**SECTION 4.55(1A) MODIFICATION APPLICATION TO SSD 16_7919 - RESPONSE TO RFI 2
85 CARABELLA STREET, KIRIRIBILLI**

This response to request for additional information is provided to address your letter dated 12 August 2019. A response to each of the Department's queries is outlined below. A response is also provided to the public submission received from the owners of 22 Elamang Avenue, Kirribilli.

project code	sheet no.	revision
LKIC	DA-3003	02

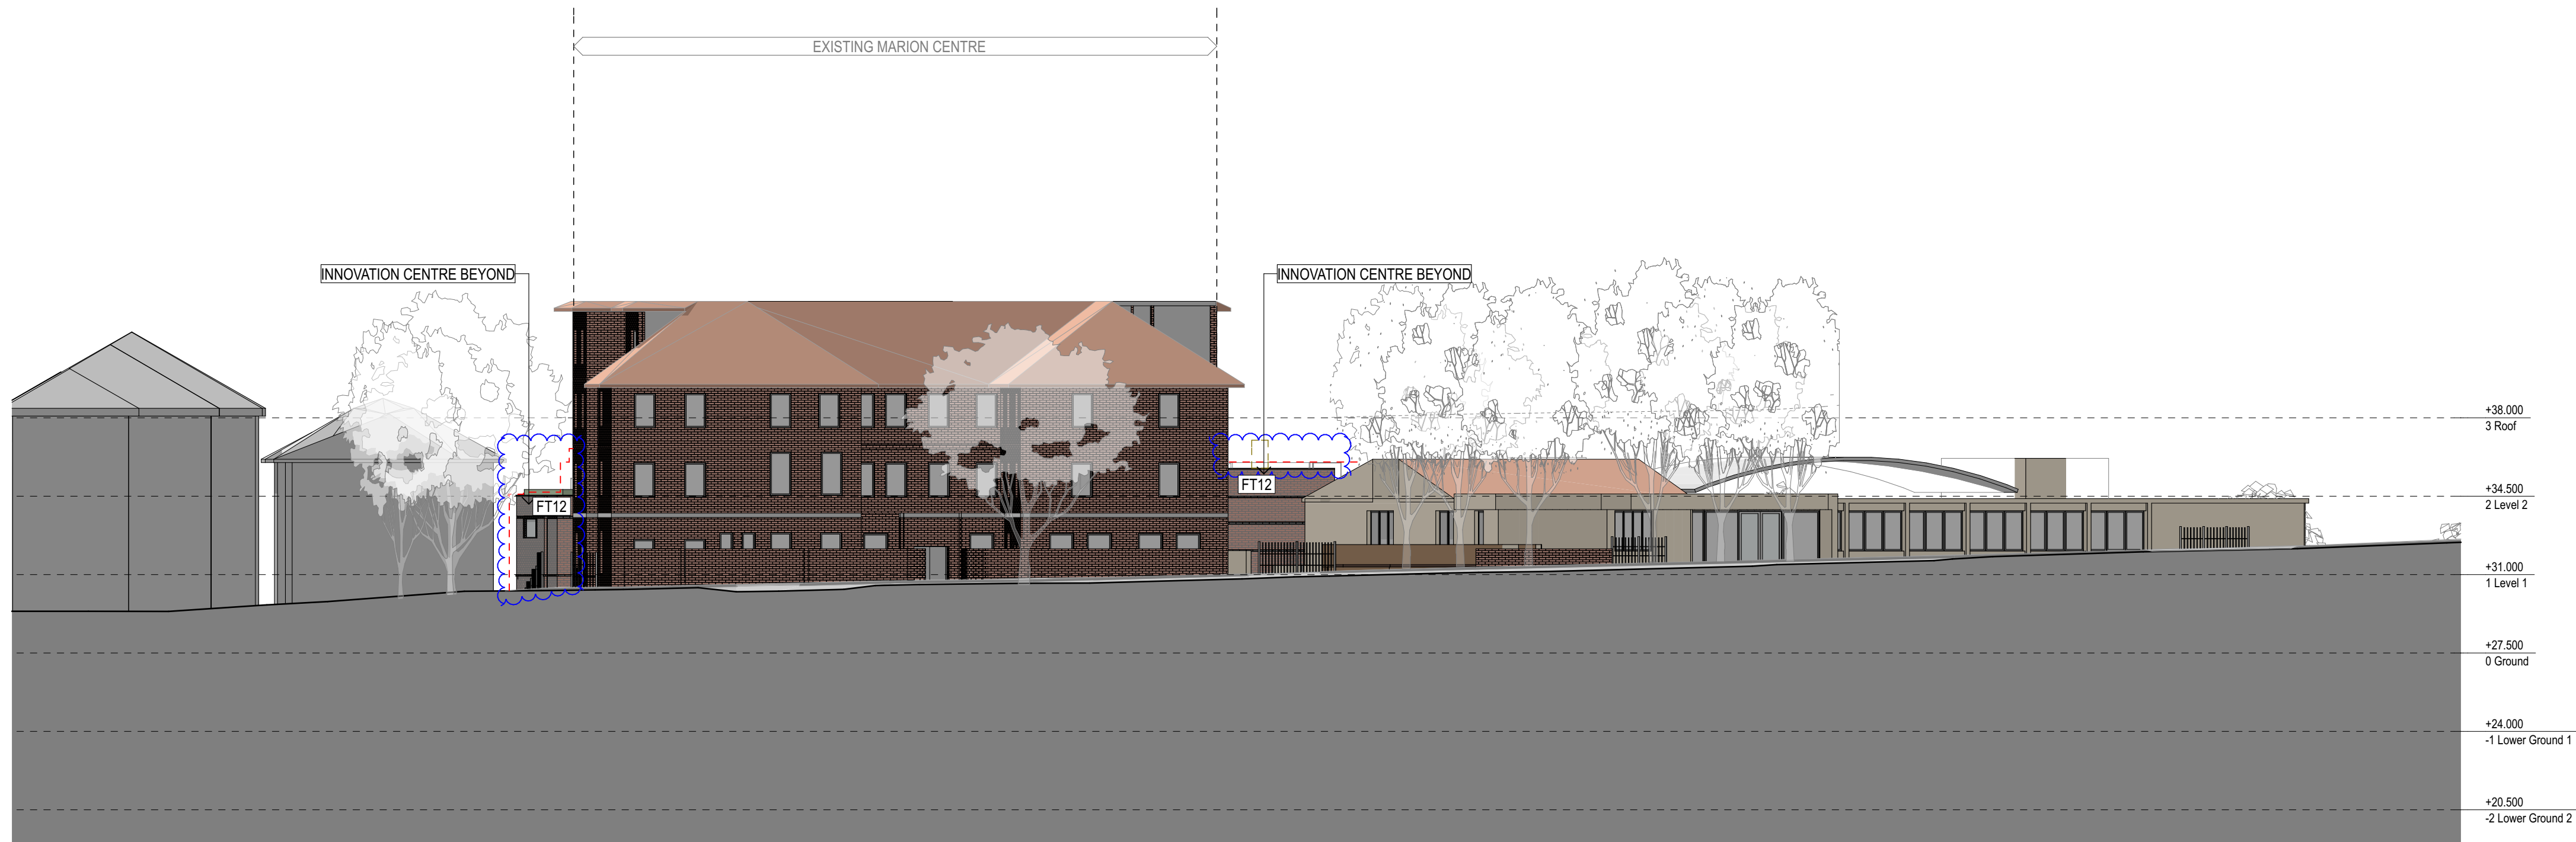
These elements / features are not reflected on the Western Elevation (drawing no. DA-3303 Rev 1). Please clarify what these features are (including any retaining walls in the excavated area) and amend the elevation to include the additional elements including the windows, if any.

2. *An emergency walkway is proposed along the western elevation of the gymnasium, which would extend to the landscaped deck at the Elamang Avenue frontage. Please confirm whether a balustrade is proposed along the western edge of this walkway. Currently, the plans do not indicate a balustrade, however it is shown on the western elevation (DA-3303 Rev 03).*

3. *As previously requested by the Department, the landscape plans are required to include all Relative Levels (RLs). The Department notes that the landscape plans for Stage 1 generally include levels except the western section (adjoining the gymnasium) where an embankment is proposed. Please provide the RLs to confirm the top and bottom of the landscaped embankment between the walkway and the site boundary. In the case where an embankment is not proposed at this location, please confirm whether the walkway is proposed to be supported on columns (currently not shown on plan or elevation).*

Currently we have not submitted a drawing numbered DA-3303. It is assumed that the Department is referring to DA-3003.

The circular features shown on DA-2201 Rev 03 are structural piles required to retain soil from the adjoining vacant land referred to as Lot 1 in DP 115513. The piles are underground, so they cannot be seen on the Western Elevation. The area to the west of the piles is existing soil battered down from the boundary towards the east. Only the top of the batter can be seen on the Western Elevation.

High level windows on the gymnasium are shown on the submitted Western Elevation (DA-3003 Rev 1). Please refer to DA-3003 (attached) and the explanatory diagrams at **Figures 1 and 2**.

The double lines on plan DA-2201 indicate the walkway balustrade.

Columns are proposed under the suspended walkway. Refer to amended drawings DA-2201 and DA-3003 (attached) and the explanatory diagram at **Figure 3**.

The majority of the retaining wall will remain. This is shown on the annotated elevations at **Figures 2 and 3** above. It is noted that appearance of the wall on the Western Elevation has changed as a result of modifications to the landform, which has now been revised following more detailed surveys. There have not been any changes to the wall itself.
